15 December 2020

Chris Ritchie
Director – Industry Assessments
Department of Planning, Industry & Environment

Re: Your Reference: SSD-10479
200 Aldington Road, Industrial Estate, Kemps Creek.

DRAWING TITLE
Constraints Plan

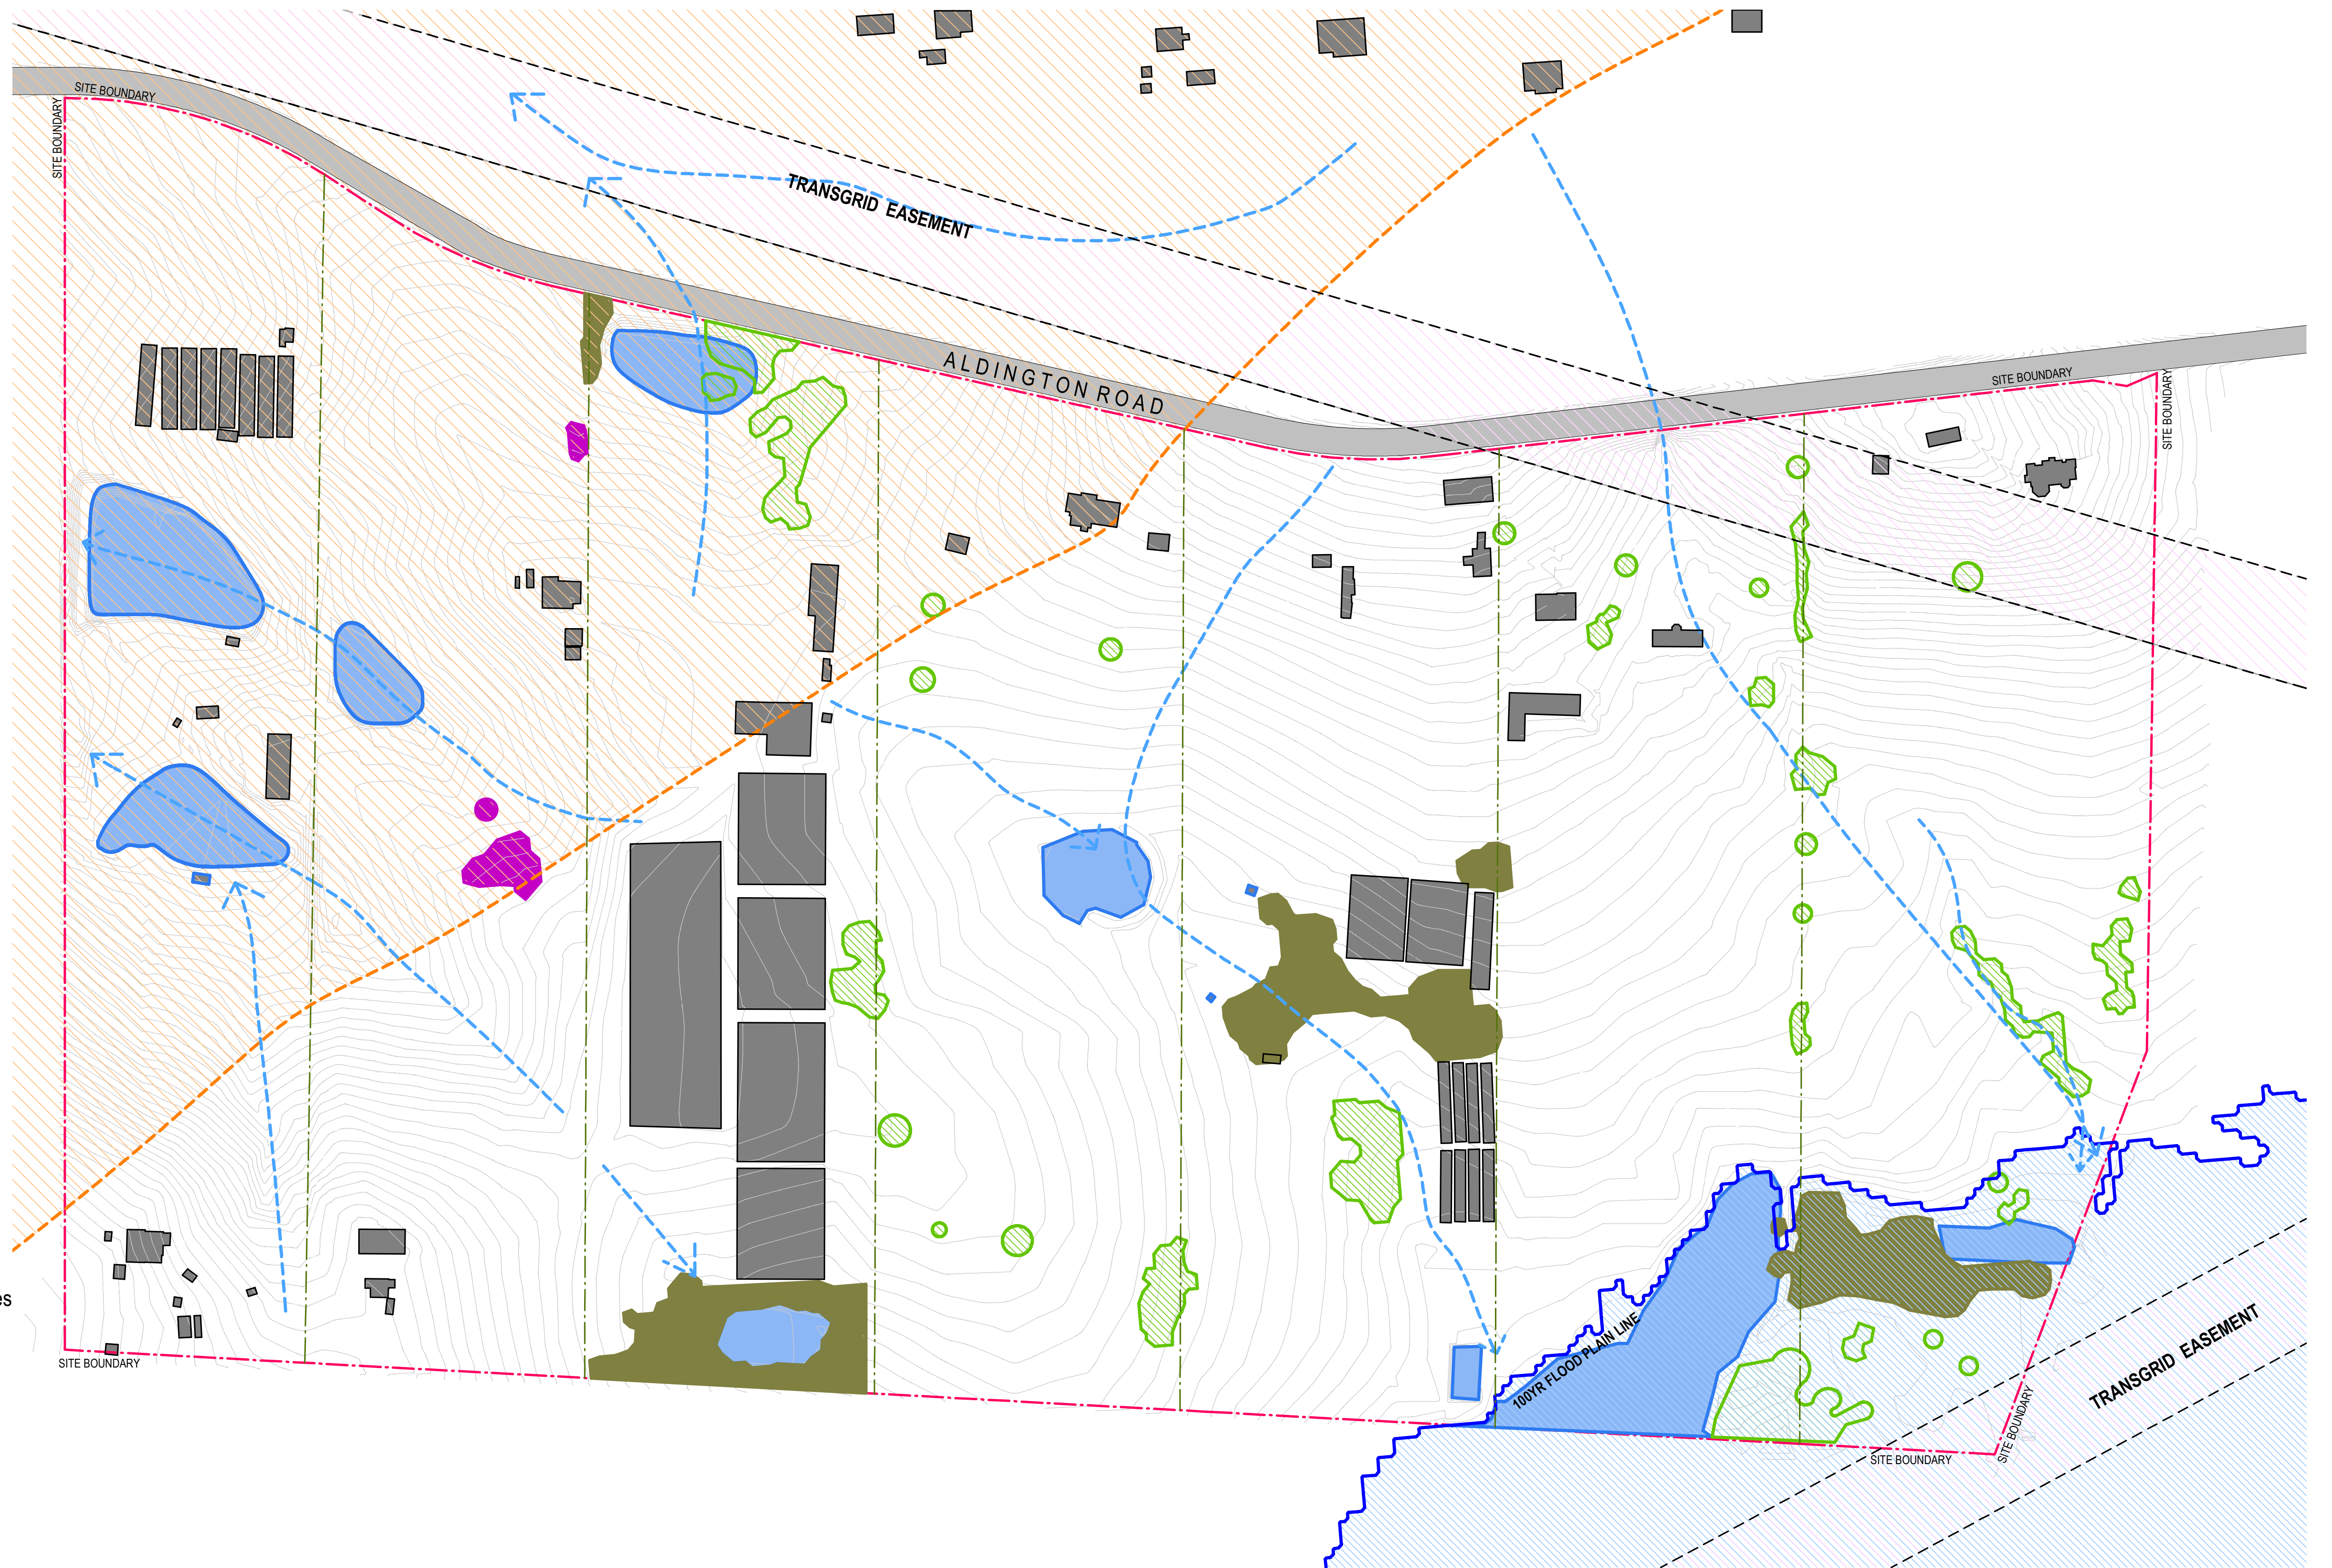
The current proposal demonstrates, that it is intended to provide retaining walls, fill the north eastern part of the SF land and locate an on-site detention basin online of a watercourse, with consequent drainage and flooding impacts onto the Pazit land. Such work does not conform with industry standard. Any discharge of additional flood water onto the Pazit land is not acceptable.

There is a multiplicity of mapping, within the application and other topographical information showing this watercourse, the tributary of Ropes Creek naturally flowing in a northerly direction from Pazit's land, onto SF land and further northwards into Ropes Creek. The notion from the consultants that the water from this watercourse flows uphill on our land and contemplable. Pazit has owned this land since 1986 and prior to that, used the land for farming, we are very aware of the sites history and constraints and the water has always flowed to the north until the dam was built across the channel.

Therefore, we submit that the development proposal by SF, should now reinstate the natural watercourse, to its historical flow path and any retaining wall on the common boundary and consequent discharge and concentration of stormwater on the Pazit land will not be accepted and strenuously contested and request alternate solutions.
